**Consultation Response from KC,
Highways Development Management**

2026/91407 7, Halifax Road, Edgerton, Huddersfield, HD3 3AN

Change of use and alteration of former Class E(e) clinic to form 7 Class C2 assisted living units with staff facilities, including removal of existing conservatory, fire escapes and doors (Listed Building within a Conservation Area)

Date Responded: 23 June 2026

Proposed Ground Floor Plan  
7 Halifax Road  
Huddersfield  
HD3 3AN

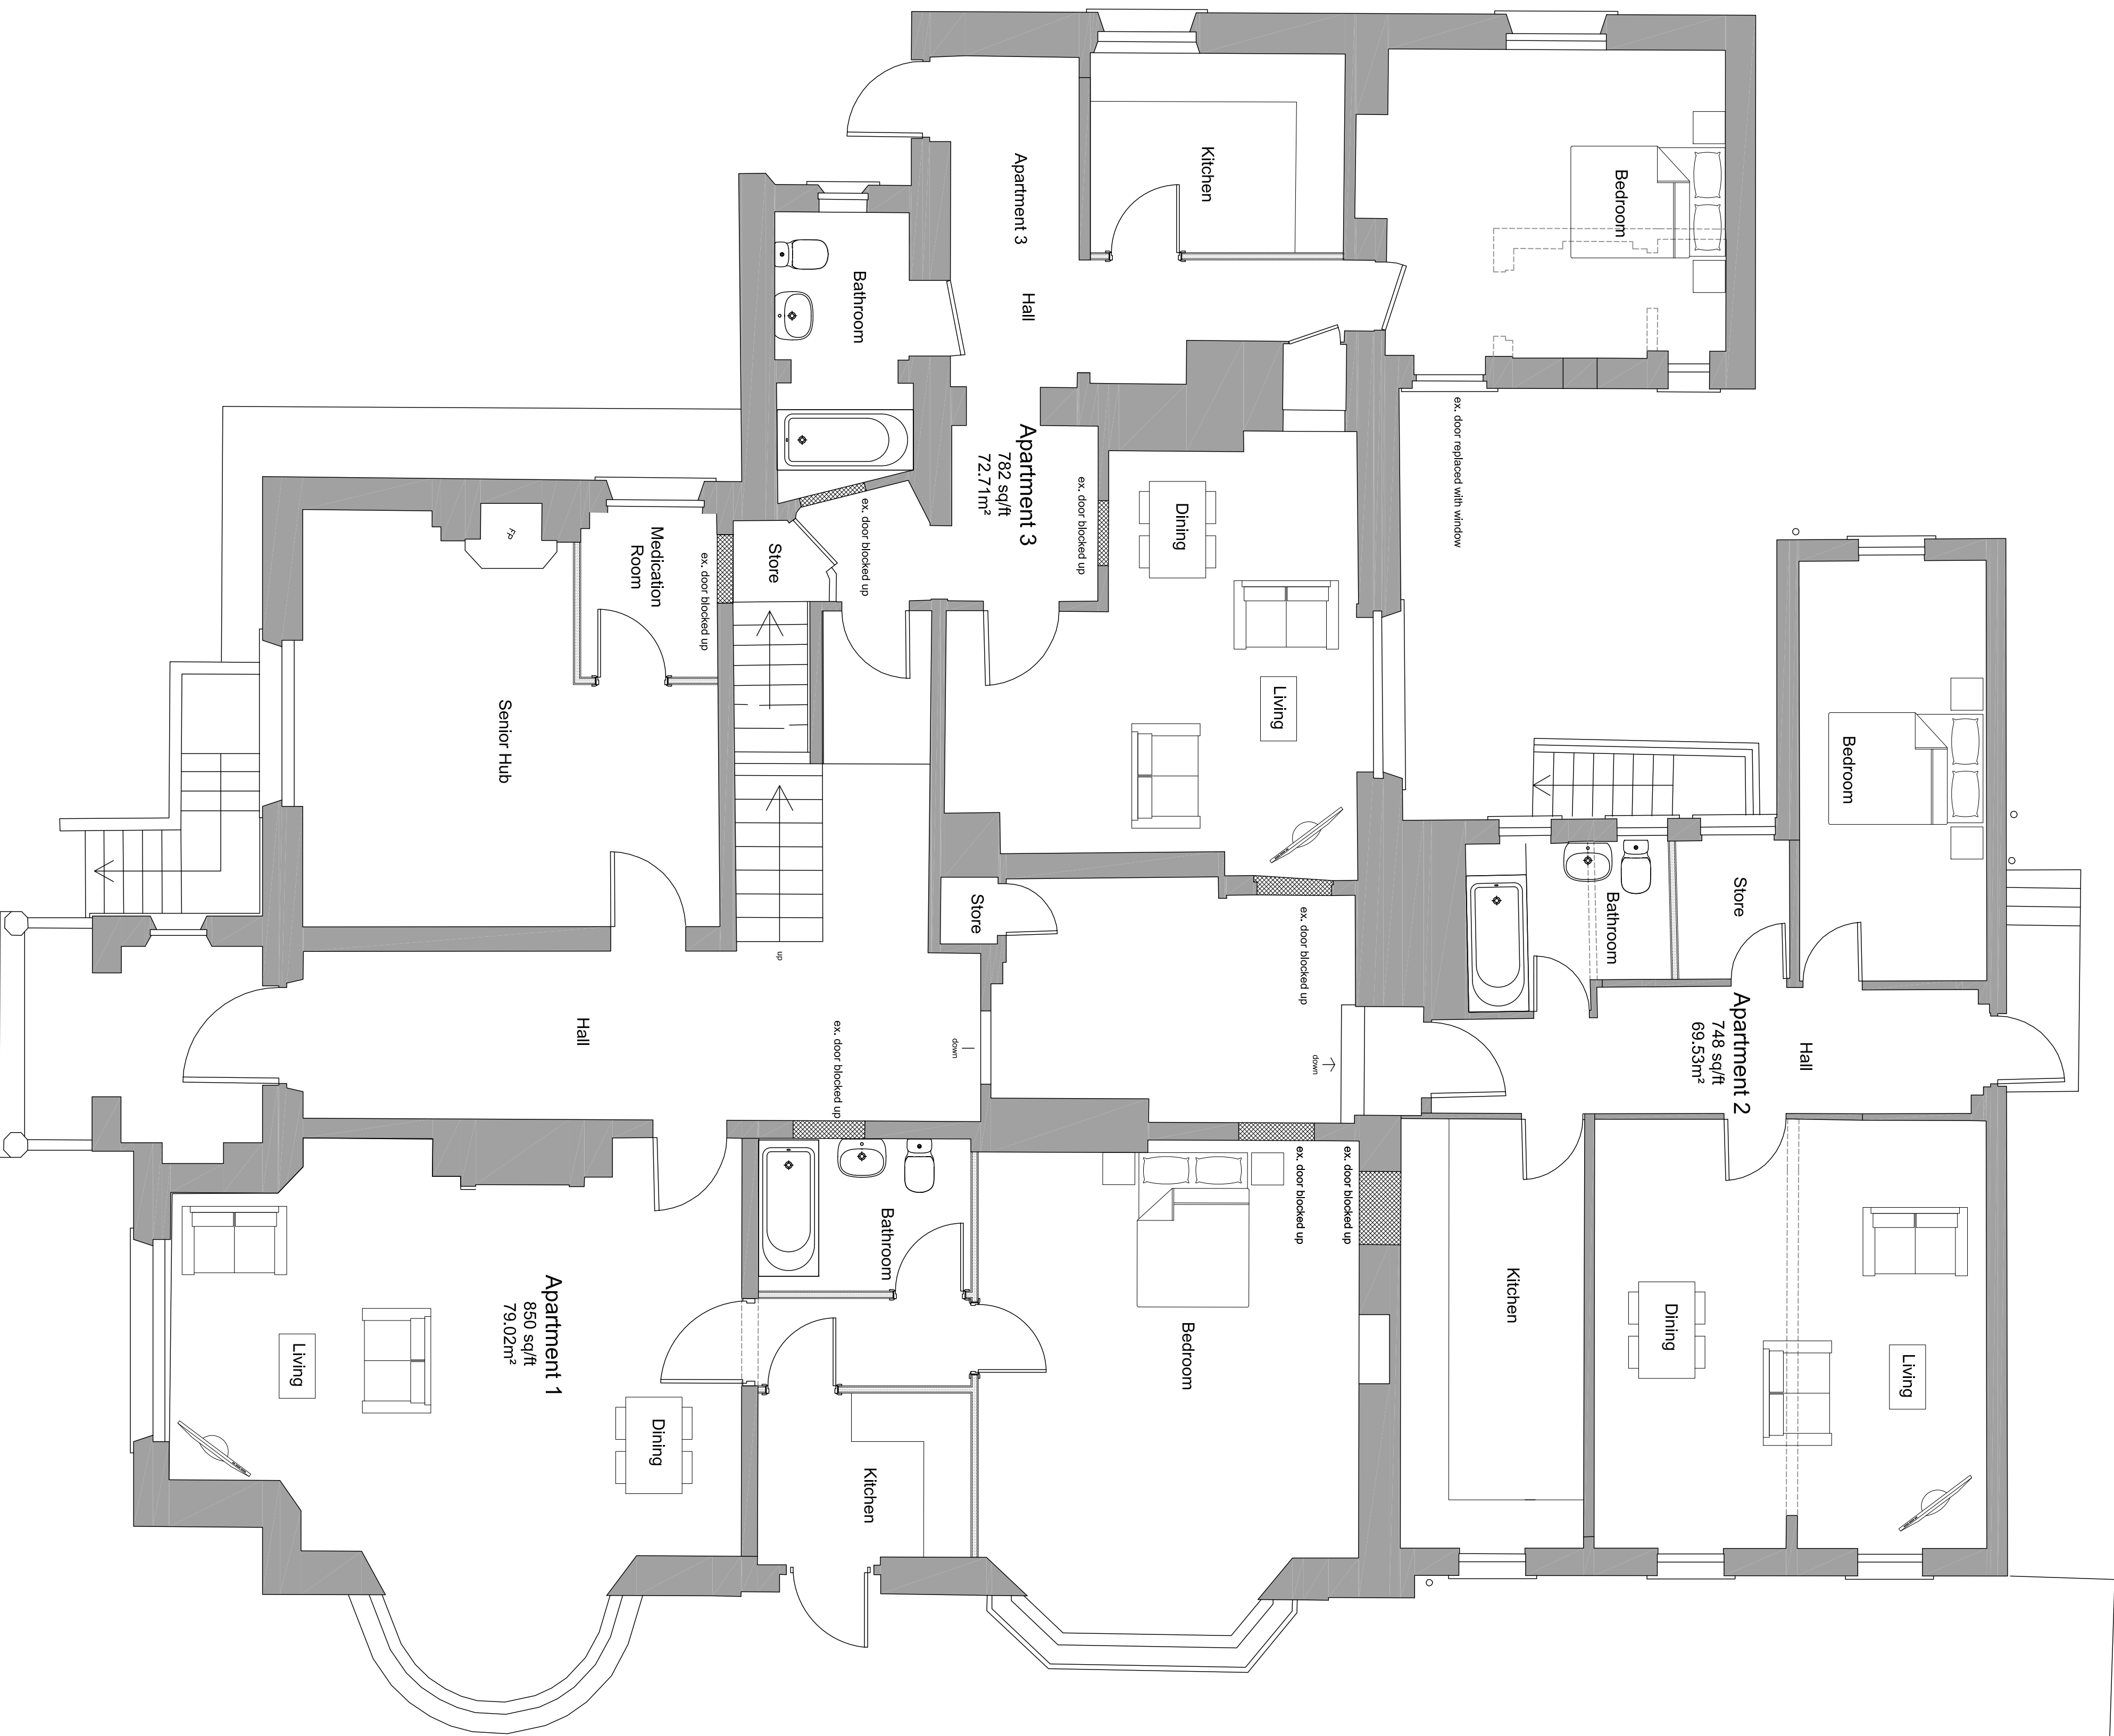
The proposed conversion from a clinic to seven assisted living units with staff facilities retains access, circulation, 18 car parking spaces, including two accessible bays, and three enclosed cycle parking spaces plus space for bin storage. There are to be 18 staff FTEs.

The amount of car parking including accessible bays is expected to remain adequate given the nature of the residential accommodation, number of staff working shifts and its similarity to the current use as a clinic and a lapsed consent for seven apartments 2015/91154, so meeting policy LP22.

Cycle parking is low for the number of staff but could be added too if there is a greater take-up.

There is space for service vehicles and for an ambulance to access and turnaround facilitating forward gear entry and exit.

Consideration should be given to installing:

- Two-three electric vehicle charging points should be considered to support sustainable travel, and lowering emissions under LP20 and LP24.
- One to two motorcycle parking spaces.
